# Planning Statement - Section 146B Alteration Request (ABP PA92.319013)

**Alterations to the permitted design of the replacement of  
renewable energy plant**

## **Medite DAC Europe**

12 August 2025

C

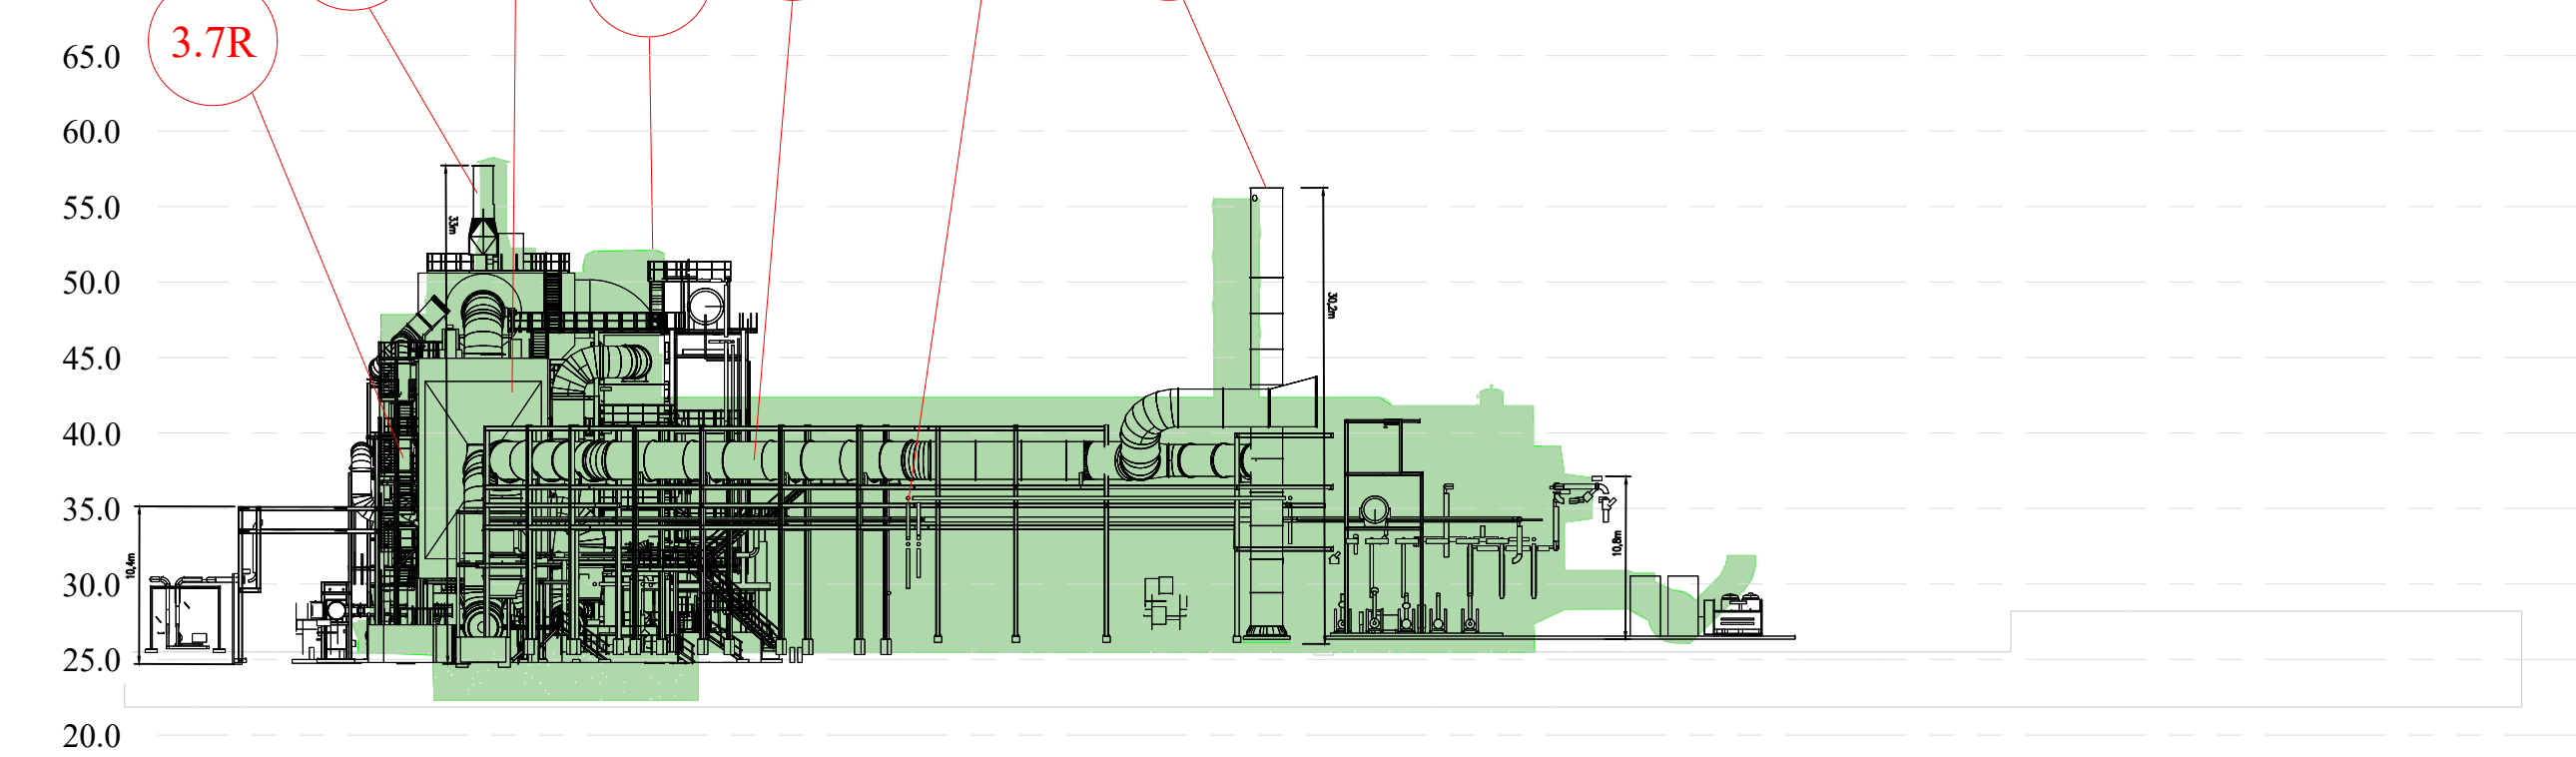
No.	Permitted Item	Description	No. (R)	Proposed Alteration Dimensions	Summary of Alterations
ITEM 3.1	Line 1 Wet Fuel Metering Bin (18.6m x 15.7m x 4.5mH) Area = 254.5 <sup>5</sup> 292.0m <sup>2</sup>	The wet fuel (bark or chips) is received by the Wet Fuel Metering Bin from the conveying systems referred to in Development Area 1.	ITEM 3.1R	Line 1 Wet Fuel Metering Bin 28.8m 7.4m x 10.3mH  Difference in dimensions: +10.2m x -8.3m x +5.8m H	<b>Proposed Area:</b> 213.1m <sup>2</sup>  <b>Area difference:</b> a reduction of -78.9m <sup>2</sup>  Resized & relocated to match operational requirements.  <b>Height increase:</b> +5.8m giving a total height of 10.3m.

ITEM 3.2	Line 1 Energy System Fuel Feed Conveyor (33.2m L x 1.1m W conveyor Max Height 17.8m) Area = 38.0m <sup>2</sup>	The Wet Fuel will be discharged from the Wet Fuel Metering Bin to a Line 1 Wet Fuel Metering Bin Outfeed Weight Belt and a Line 1 Energy System Fuel Feed Conveyor to the Grate Furnace Combustion Chamber with the energy plant.	ITEM 3.2R	Line 1 Energy System Fuel Feed Conveyor 31.4m L x 1.0m W conveyor Max Height 20.7m  Difference in dimensions: -1.8m L x -0.1m x +2.9m H	<b>Proposed Area:</b> 31.4m <sup>2</sup>  <b>Area difference:</b> a slight reduction of -6.6m <sup>2</sup>  Adjusted to accommodate metering bin and energy plant

ITEM 3.3	Line 1 Energy Plant 32.5m x 21.6m x 33m	The energy plant will consist of a wood biomass fired Thermal Fluid Heater (TFH). Inside the TFH, the Wet Fuel will combust	ITEM 3.3R	Line 1 Energy Plant	<b>Proposed Area:</b> 592.2m <sup>2</sup>

No.	Permitted Item	Description	No. (R)	Proposed Alteration Dimensions	Summary of Alterations
	Area = <del>442m<sup>26</sup></del> 702m <sup>2</sup>	<p>together with fresh air provided by the Primary Fan and Secondary Fan inside the Combustion Chamber to produce hot flue gas.</p> <p>An emergency stack on the TFH with a damper will automatically open upon upset conditions. The hot flue gas will supply heat to a thermal fluid that is piped through the energy plant, which in turn provides heat to the Line 1 press and a Steam Generator).</p> <p>There are no changes associated with the regulated release points (Core Dryer A2-5 and Face Dryer A2-6).</p>		<p>28.2m x 21.0m x 33mH: Stack Height</p> <p><b>Difference in dimensions:</b> -4.3m x -0.6m x 0mH</p>	<p><b>Area difference:</b> a reduction of -109.8m<sup>2</sup></p> <p>Reduced size &amp; minor re-location. Moved by 11.8m west to accommodate equipment. This is not a continuous emission point.</p>

ITEM 3.4	<p>Line 1 Dry Electrostatic Precipitator (within the TFH dims of 27.6m x 13.7m x 23.3mH ) Area = 286.9 m<sup>2</sup></p>	The Fly Ash inside the Hot Gas will be cleaned and captured by a Dry Electrostatic Precipitator (Dry ESP) and discharged through the SSC Rotary Airlock onto the Wet Ash Conveyor. The Bottom Ash will be discharged through the holes on the grate and recovered by the Wet Ash Conveyor to the Ash Storage Bunker for disposal.	ITEM 3.4R	<p>Line 1 Dry Electrostatic Precipitator (within the TFH dims of 24.5m x 11.1m x 23.3.0mH</p> <p><b>Difference in dimensions:</b> -3.1m x -2.6m x 0mH</p>	<p><b>Proposed Area:</b> 271.9m<sup>2</sup> <b>Area difference:</b> a slight reduction of -15.0m<sup>2</sup></p> <p>Resized &amp; Location moved to accommodate equipment</p>

ITEM 3.5	<p>Line 1 Hot Gas Duct 105m long x Ø3.2m Area = 336.0m<sup>2</sup></p>	The Hot Gas will be transported to the Line 1 Dryer Systems (Core and Face dryers) via the Hot Gas Duct where it will be mixed with ambient air for the purpose of drying the wet wood fibre. The existing mixing chambers located within the Line 1 Dryer Building will be modified to accommodate the new hot gas duct.	ITEM 3.5R	<p>Line 1 Hot Gas Duct 98.1m long x Ø2.6m</p> <p><b>Difference in dimensions:</b> -6.9m x Ø-0.6m</p>	<p><b>Proposed Area:</b> 255.0m<sup>2</sup> <b>Area difference:</b> a reduction of -81.0m<sup>2</sup></p>

No.	Permitted Item	Description	No. (R)	Proposed Alteration Dimensions	Summary of Alterations
ITEM 3.6	Line 1 Start Up Stack (30.2mH x Ø3.6m) Area = 10.8m <sup>2</sup>	The Hot Gas duct will contain an abort gate & Start-up Stack. This Abort Gate and start-up stack serves as a by-pass of the Hot Gas Flow to the dryer to atmosphere in case the dryer system is in upset conditions or during plant start-up.	ITEM 3.6R	Line 1 Start Up Stack 30.2mH x Ø2.7m  Difference in dimensions: 0mH x -0.9m	<b>Proposed Area:</b> 9.0m <sup>2</sup>  <b>Area difference:</b> a slight reduction of -1.8m <sup>2</sup>  Moved due to constructability constraints 30.2 m height is maintained and relocated by 10.3m east. This change will not affect the assumptions in the EIAR as it is not a continuous emission point.

ITEM 3.7	Line 1 Sander Dust Silo (Ø 6.0m x 16mH) Area = 28.3m <sup>2</sup>	As referenced in 'Pneumatic (Dry Fuel) Systems' in Development Area 1, the existing extraction systems are to be modified and will a proposed Sander Dust Silo Ø 6.0m x 16mH and associated filter plant, located adjacent to the proposed Line 1 Energy Plant. The Sander Dust Silo will discharge material into the Line 1 Energy Plant as fuel.	ITEM 3.7R	Line 1 Sander Dust Silo (Ø 3.0m x 13.3mH) Difference in dimensions: 0m	<b>Proposed Area:</b> 9.0m <sup>2</sup>  <b>Area difference:</b> reduction of -19.3m <sup>2</sup>  Incorporated into the frame structure of the to the energy plant

ITEM 3.8	Line 1 Thermal Fluid Piping 217m L x Ø 0.6m x 16.3mH Area = <del>40.9</del> 130.2 m <sup>2</sup>	The Thermal Fluid Piping will transport the heated thermal fluid to and from the energy plant and both the existing Line 1 Press and a new steam generator.	ITEM 3.8R	Line 1 Thermal Fluid Piping 107.1m L x Ø 0.3m x 10.3mH Difference in dimensions: -109.9m x Ø-0.3m	<b>Proposed Area:</b> 32.1 m <sup>2</sup>  <b>Area difference:</b> a reduction of -98.1 m <sup>2</sup>

ITEM 3.9	Line 1 Steam Generator 14.4m x 3.5m x 17.9mH Area = 47.5m <sup>2</sup>	The Steam generator will use heated thermal fluid to generate steam for the various existing steam users on Line 1. The new steam piping will connect the steam generator to the existing steam pipe infrastructure.	ITEM 3.9R	Line 1 Steam Generator 13.5m x 4.4m x 10.8mH Difference in dimensions:	<b>Proposed Area:</b> 59.4m <sup>2</sup>  <b>Area difference:</b> an increase of +11.9m <sup>2</sup>

No.	Permitted Item	Description	No. (R)	Proposed Alteration Dimensions	Summary of Alterations
				-0.9m x +0.9m x -7.1mH Reduction of external works as re-located inside existing building.	Reduction in height of pipe work
ITEM 3.10	Line 1 Dryer System 34.0m x 17.5m x 13.9mH Area = 505.7m <sup>2</sup>	The Hot Gas generated by the new Line 1 Energy plant will be utilised in the dryer system to dry wood fibre to produce MDF.	ITEM 3.10	Line 1 Dryer System 34.0m x 17.5m x 13.9mH Area = 505.7m <sup>2</sup> As permitted; Inside existing building	No Area Difference
ITEM 3.11	Line 1 Bunded Oil Storage 10.4m x 6.4m x 3.1mH Area = 66.5m <sup>2</sup>	Bunded Oil Storage Tank	ITEM 3.11R	Line 1 Bunded Oil Storage 10.5m x 6.9m x 3.9mH Difference in dimensions: +0.1m x +0.5m x +0.8mH	<b>Proposed Area:</b> 72.5m <sup>2</sup> <b>Area difference:</b> an increase of +6.0m <sup>2</sup>
